Application for Exemption from Site Plan Review

PROJECT NAME: Mike Murphy Washington Ave 1771

PROJECT ADDRESS: 1771 WASHINGTON AVE

Install new Driveway

Existing Garage Doors to
BE MOVED..

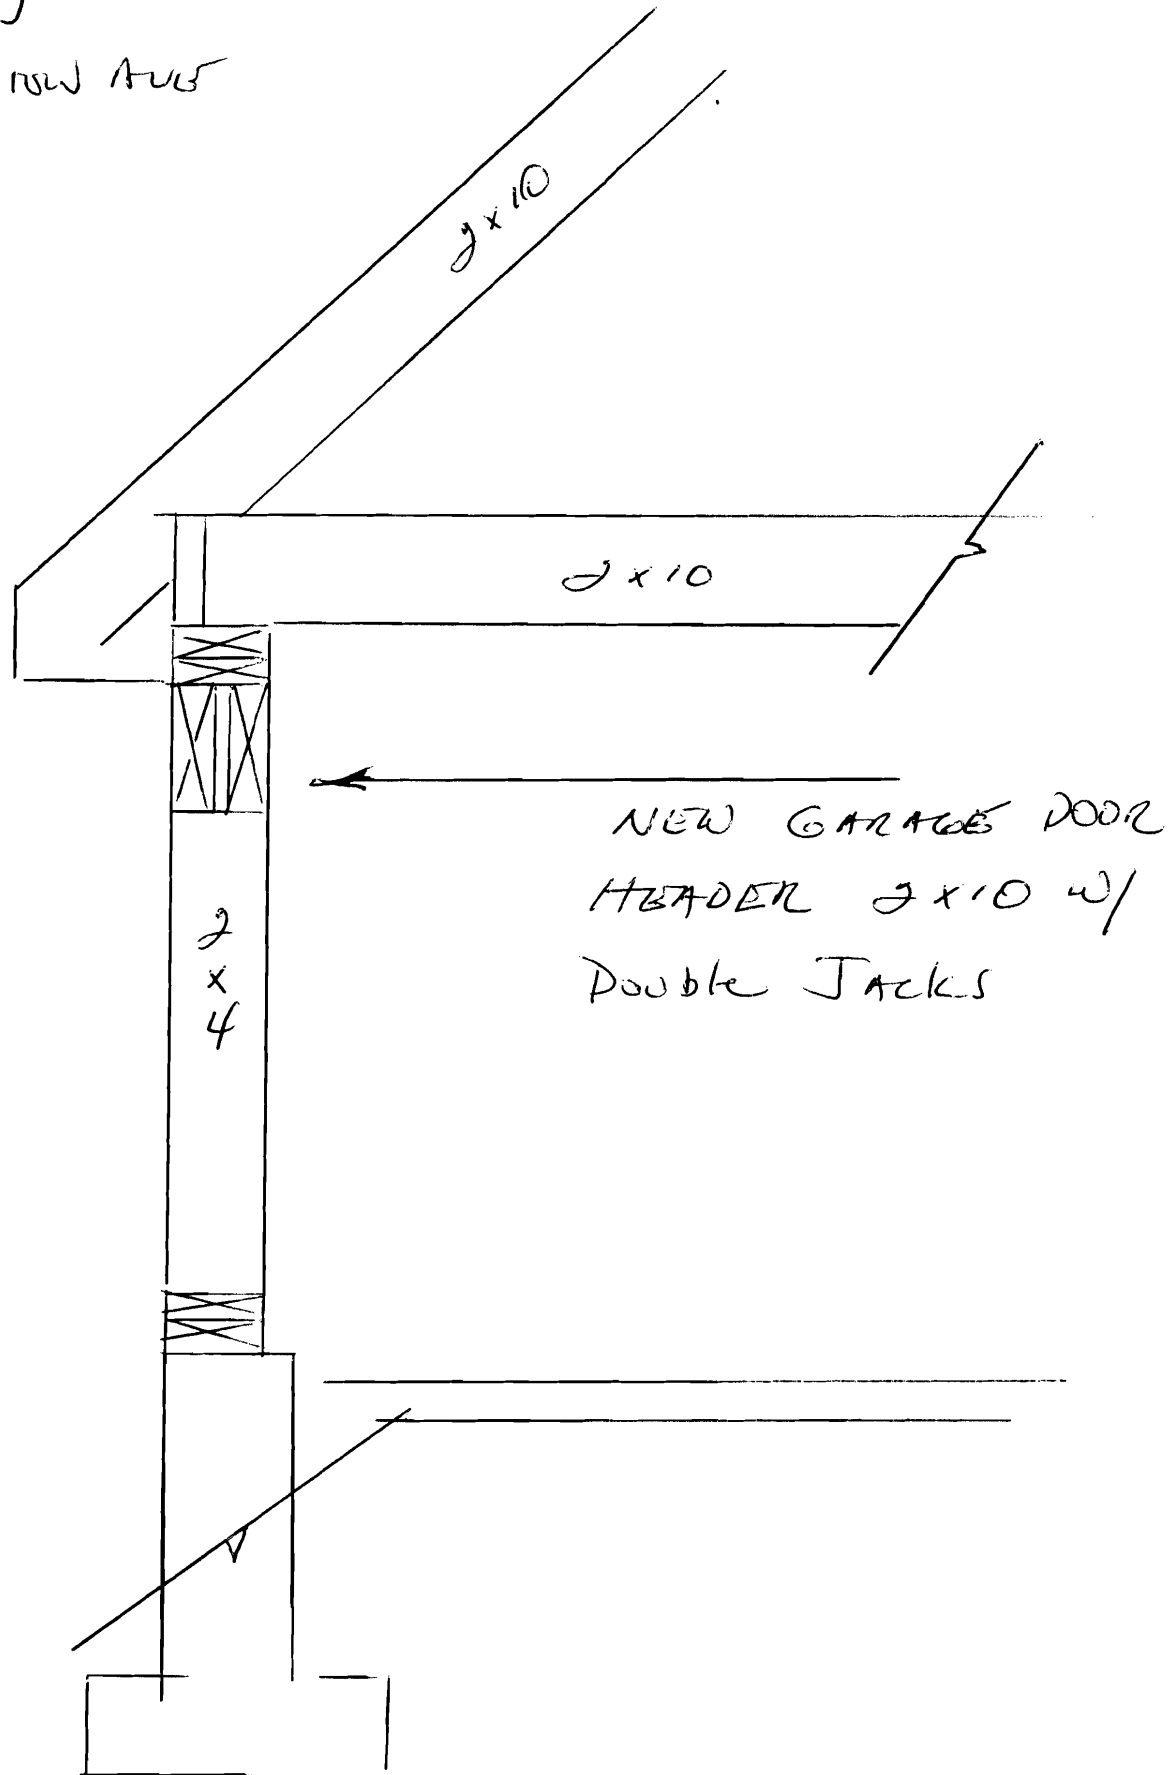
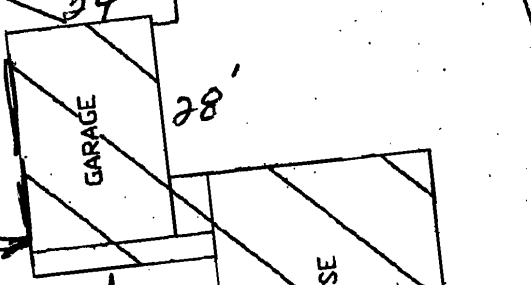
I called Don Morin on 5/26. He told me the driveway separation is 60 feet and that the area where cars are parked now will be loamed and seeded. I presented it at the Development Review meeting on 5/27/09. Consensus of the group is that a plan needs to show the items noted above and that the applicant needs a permit from Public Services for a new curb cut in addition to the building permit for the garage.

I contact Mr. Morin on May 29th and have requested that a revised plan be submitted that reflects the separation between the existing and proposed driveway and shows the area to be loamed and seeded.

The revised site plan is exempted from review (stamped approved). Tom Errico, Consulting Traffic Engineer, approved the location on June 12th and David Margolis-Pineo approved it on June 15, 2009. The applicant may proceed with the condition that they obtain the required curb cut permit from Public Services and building permit from the Inspection Division.
